OXFORDSHIRE COUNTY COUNCIL'S RESPONSE TO CONSULTATION ON THE FOLLOWING DEVELOPMENT PROPOSAL

Application no: 23/00853/OUT

Proposal: Outline application for up to 170 dwellings (Use Class C3) with associated open space and vehicular access off Warwick Road, Banbury; All matters reserved except for access

Location: Land East Of Warwick Road Drayton, Warwick Road, Banbury

Figure 5.2: Proposed Highway Layout

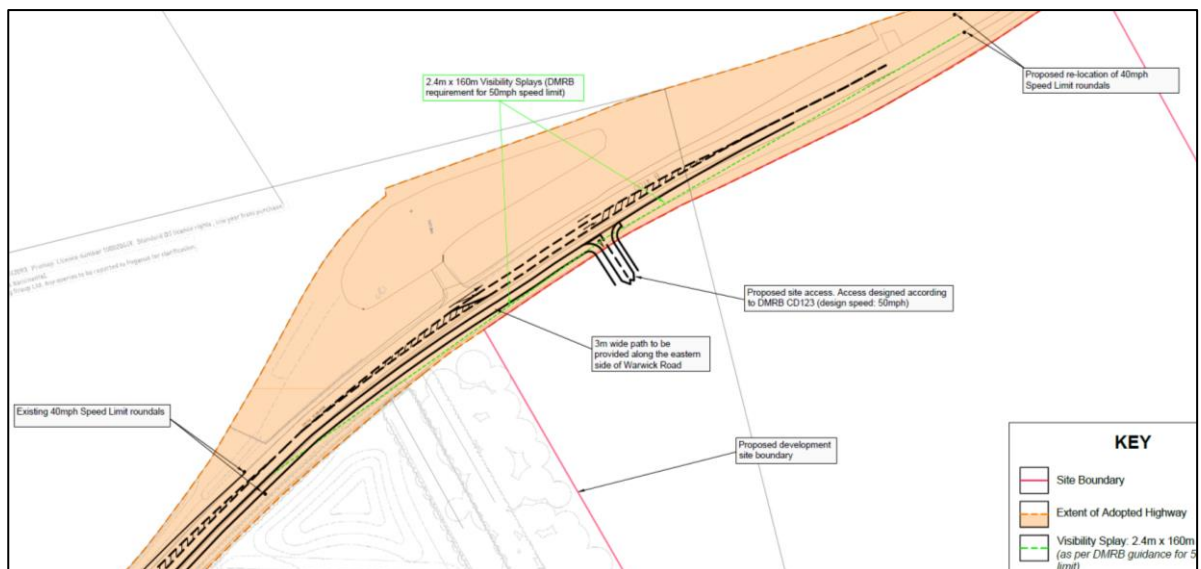
The first main point raised was around the vehicle access and the lack of vehicle tracking for service vehicles (is waste collection vehicles). Updated drawings of the access include vehicle tracking of a refuse vehicle have been included at Appendix A of the Technical Note.

This shows that whilst it is possible for the vehicle to enter and leave the development this does mean that the turning movements cause the vehicle to overhang both the footway/cycleway and the ahead lane on Warwick Road northbound which presents the risk of pedestrians/cycles being struck by turning vehicles and collisions between vehicles not anticipating the vehicle to part enter their path. As there is ample frontage to Warwick Road I am satisfied that relatively minor modifications to the junction could achieve a suitable layout and that this can be secured by planning condition. This condition should also include the detailed design of the foot/cycleway that is proposed alongside Warwick Road as it is currently directly adjacent to the carriageway whereas design guidance requires that a buffer should be provided where there is a 40 mph speed limit which will need to be larger if the reduced vehicle speeds are unlikely to be achieved.

Prior to the commencement of the development hereby approved, details of the means of access between the land and the B4100 Warwick Road including position, dimensions and layout shall be submitted to and approved in writing by the Local Planning Authority. Thereafter, and prior to the occupation of any dwellings, the means of access onto the highway shall be constructed and retained in accordance with the approved details.

Prior to the commencement of the development hereby approved full details of the foot/cycleway connection along Warwick Road that provides for a buffer between the foot/cycleway and the carriageway shall be submitted to and agreed in writing by the Local Planning Authority. The foot/cycleway shall then be completed in accordance with the agreed details prior to any occupation on the site.
